DOC21/974825-3

**EPA Advice on Submissions Report - Aus-10 Rhyolite Pty Limited – Austen Quarry
Modification 3 (SSD 6084 – Mod 3)**

The EPA has reviewed the Modification Report SSD 6084 Modification 3 by Hy-Tec Industries Pty Ltd, Modification Report – Mod 3 - Report No 652/43 October 2021 for the proposal.

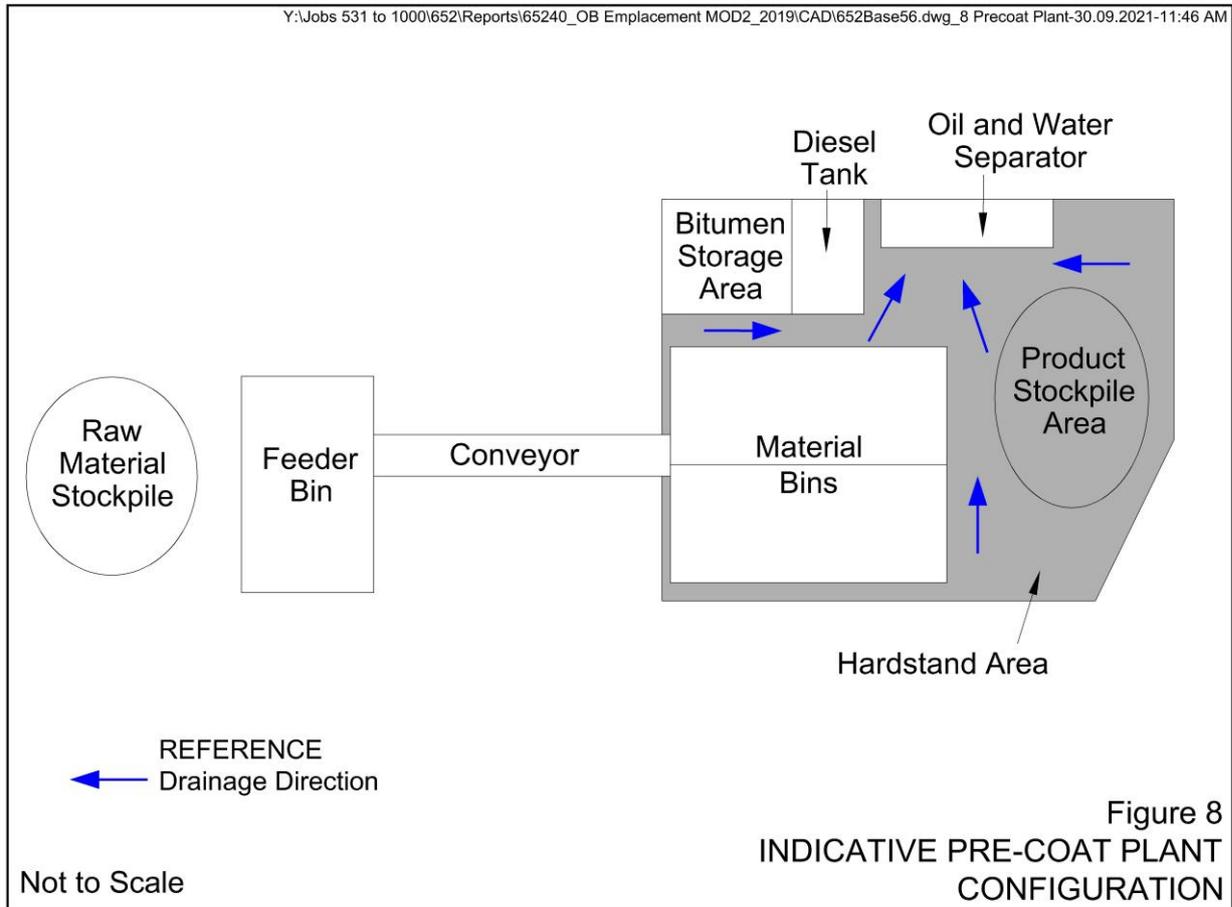
The EPA understands the proposal is for biodiversity offsetting obligations and additional processing infrastructure. The EPA's specific interest relates to the proposed installation and operation of a pre-coat plant and a pugmill within the secondary processing area.

- a) All hydrocarbons and other chemicals must be delivered and stored within a bunded area. Bunds must be sized to be 110% of the largest container and lined with an impervious material.
- b) The proponent must implement a chemical storage maintenance and monitoring program which aims to detect leakages and prevent hydrocarbon contamination of soil and groundwater.
- c) The premises water management plan must be reviewed and updated having regard to any changes in water management relating to the proposal.

Inadequate containment of chemicals and hydrocarbons has the potential to cause soil, groundwater and surface water contamination.
